## Portishead Branch Line (MetroWest Phase 1)

9.1 ExA.Sch.D3.V3 – Schedule of Changes to the draft Development Consent Order

**Log of drafting changes for Deadline 3 draft DCO**

**21 December 2020**

Drawing
**ASHTON VALE ROAD
PEDESTRIAN RAMP DESIGN**

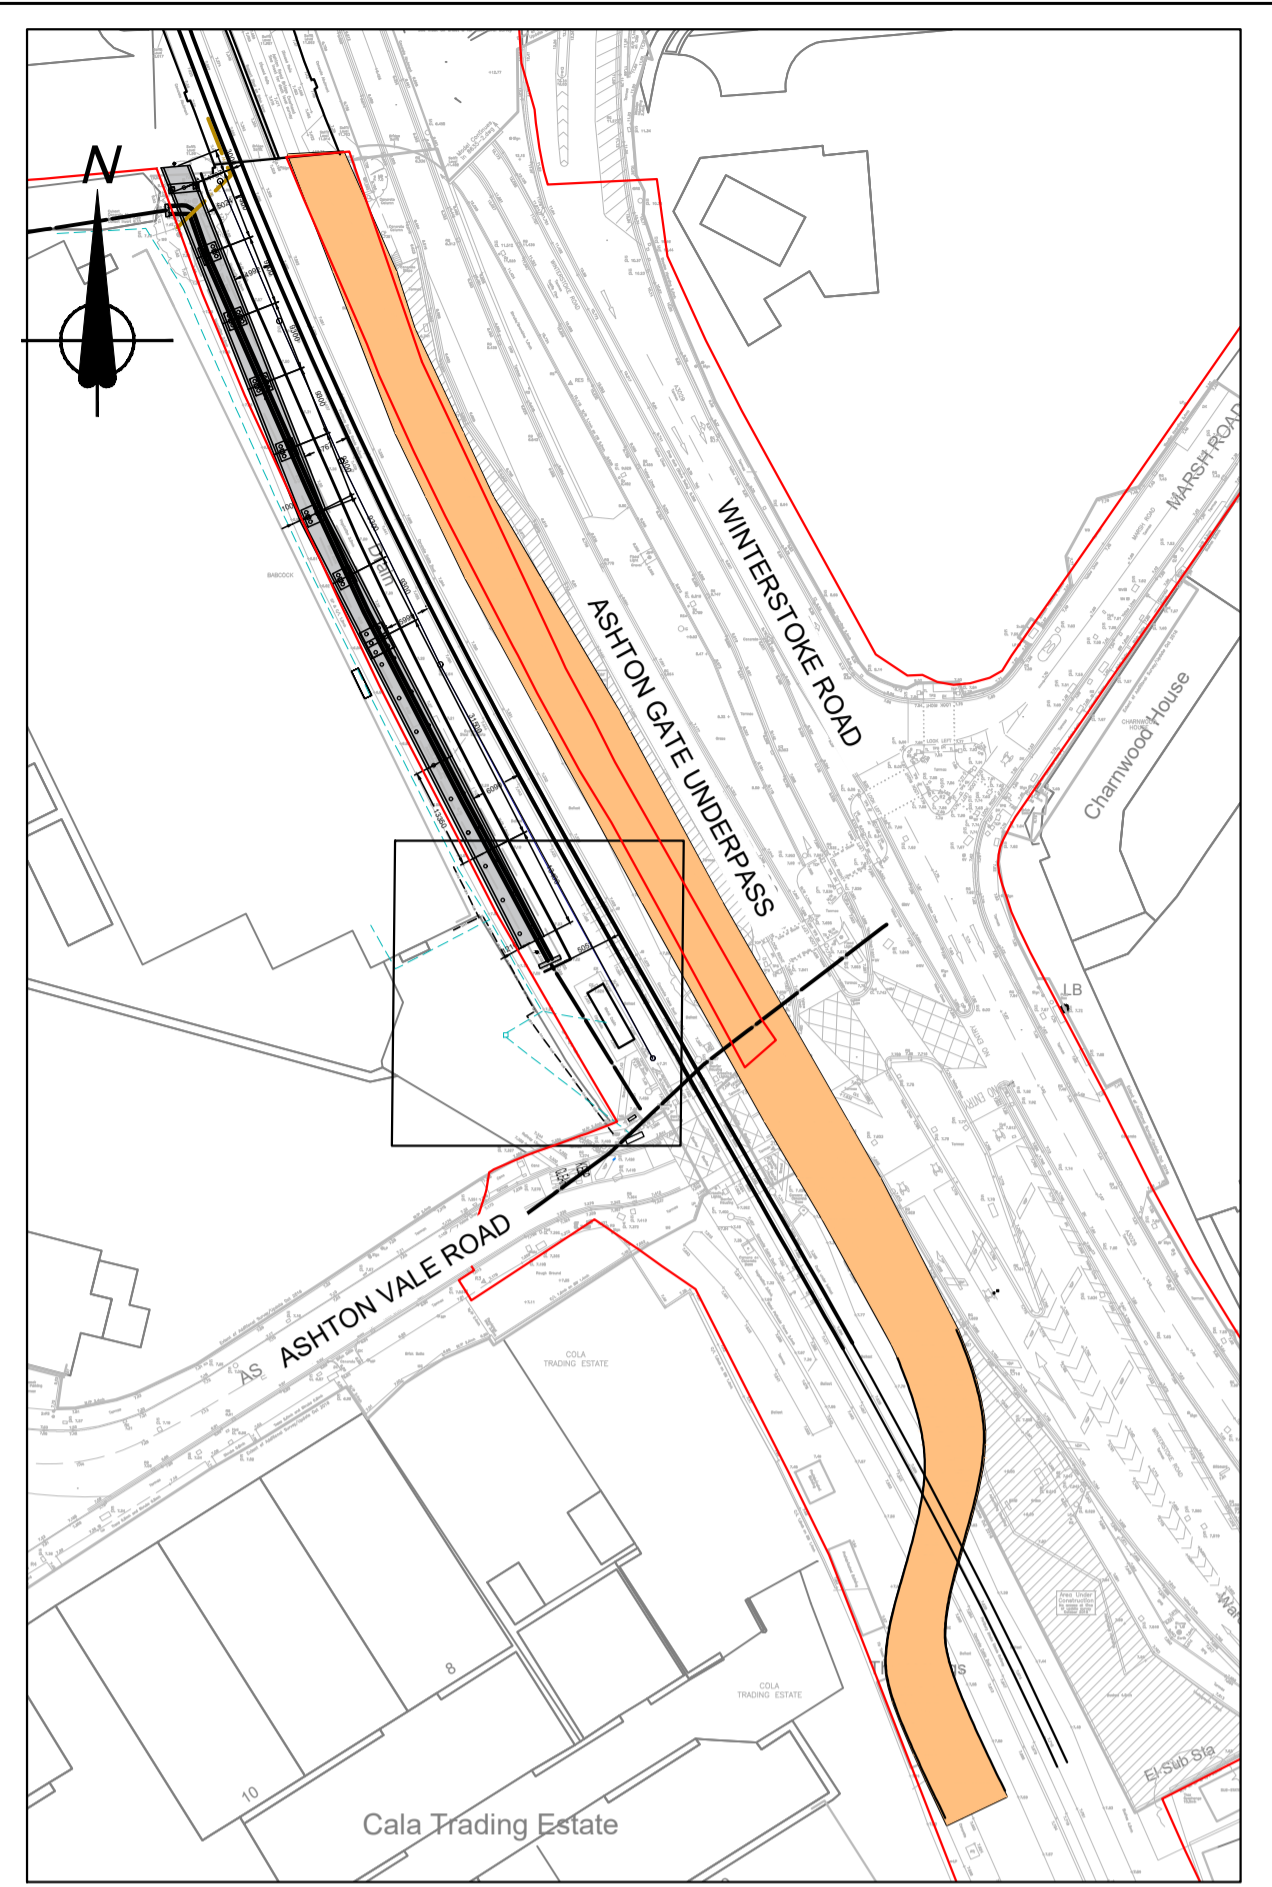
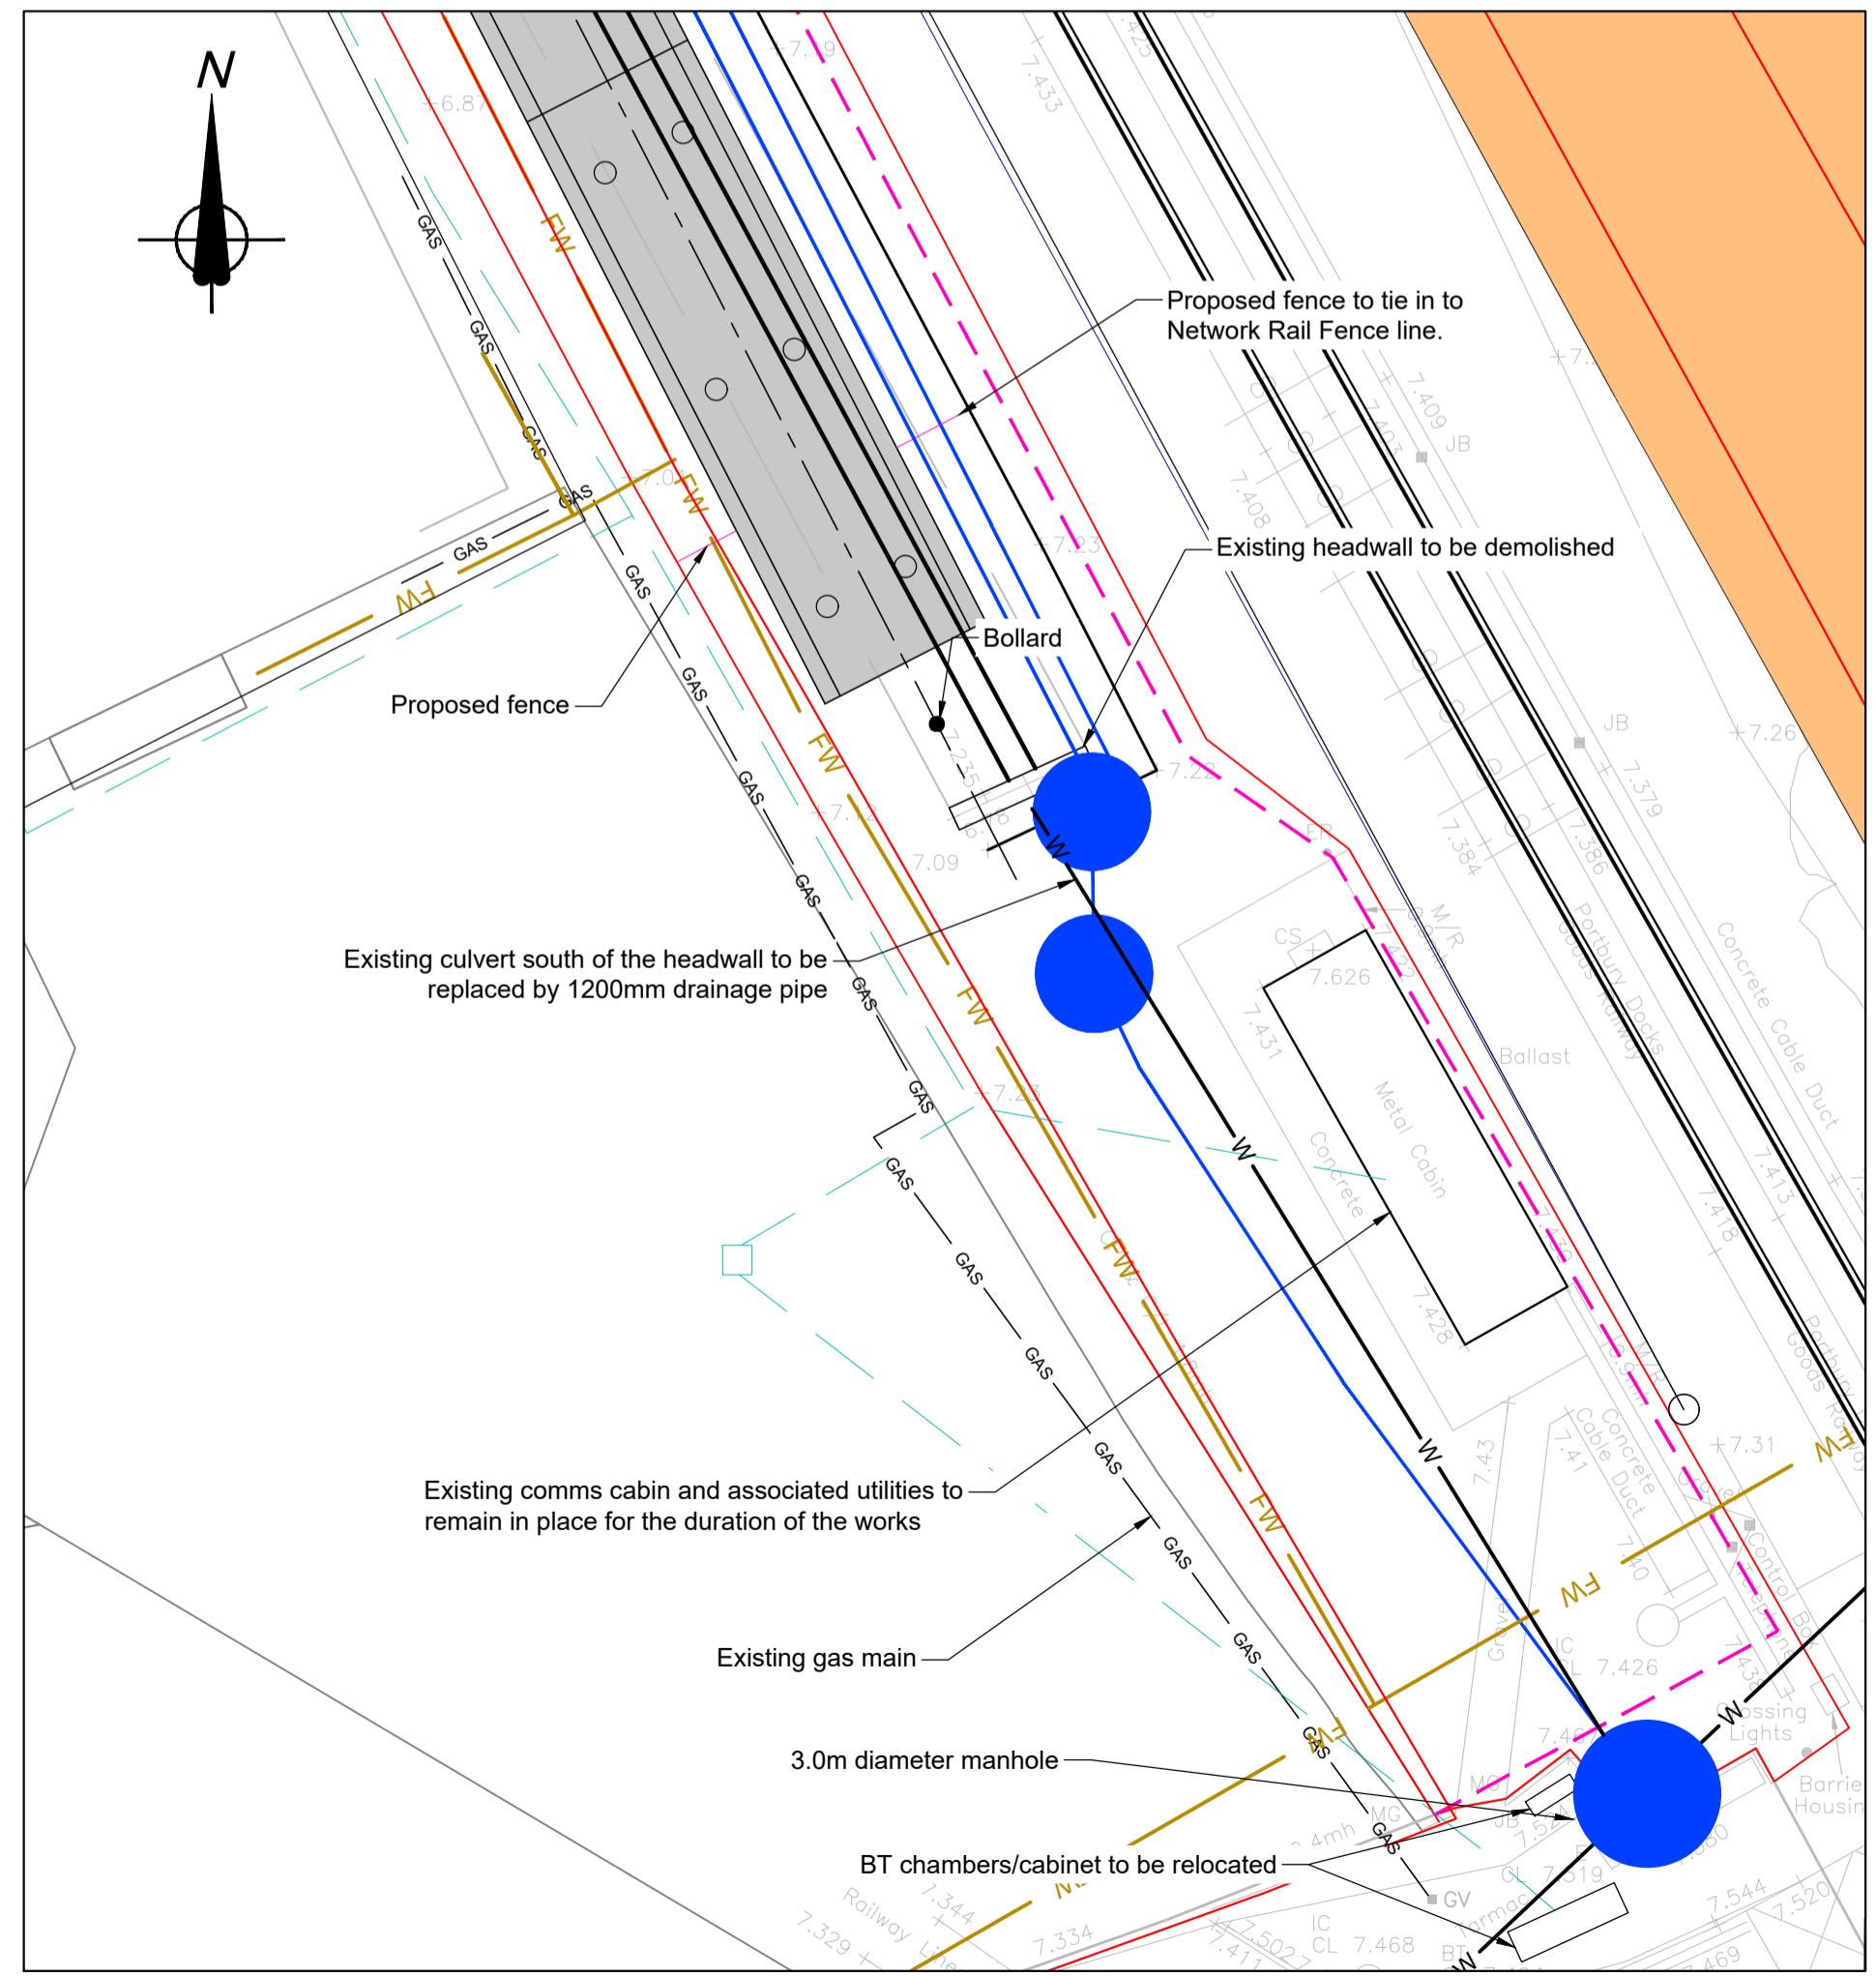
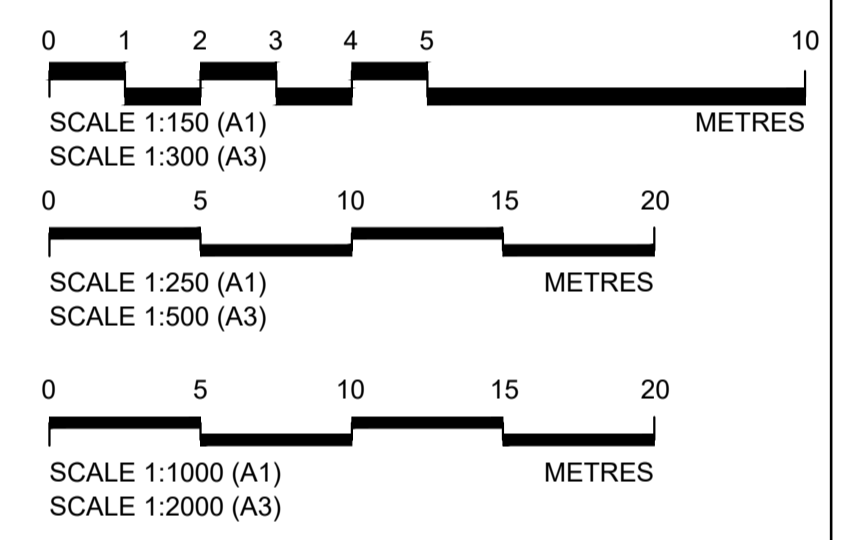
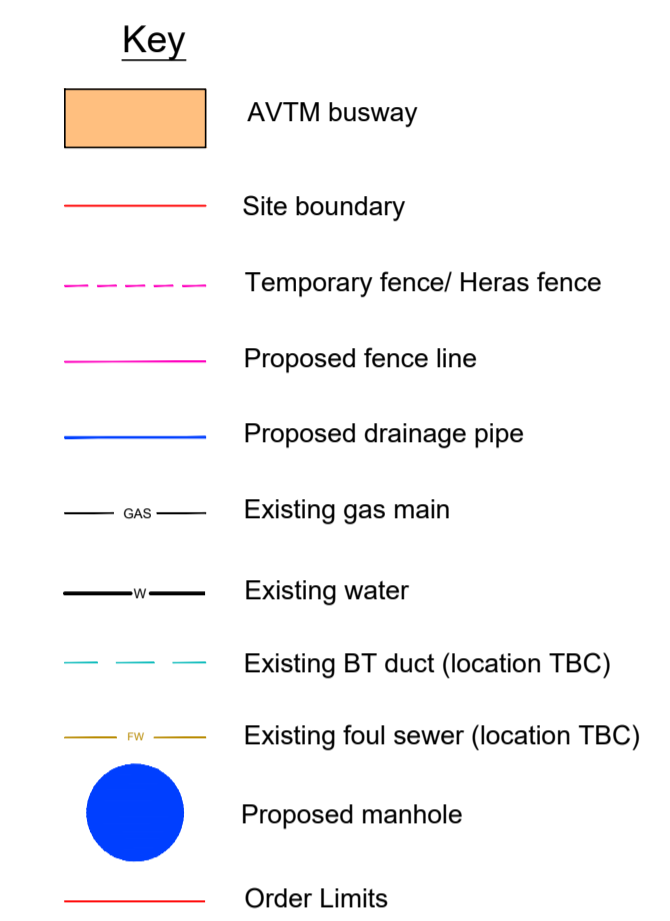
<p>highway authority. The submitted details must adhere to the principles shown on the Ashton Vale Road Pedestrian Ramp Design Plan.</p> <p>(2) Work No. 27 must thereafter be carried out in accordance with the approved details.</p>			
Schedule 17 – Documents to be Certified	Removal of number "84"	Automatic numbering had continued in error	-	-
Schedule 17 – Documents to be Certified	<p>New certified plans added:</p> <p>Ashton Vale Road and Winterstoke Road Highway Works plan</p> <p>Ashton Vale Road Pedestrian Ramp Design Plan</p> <p>Bridleway Extension Under the Elevated M5 Plan</p>	Consequential amendments arising from Works 18, 27 and 28 being removed from	-	-
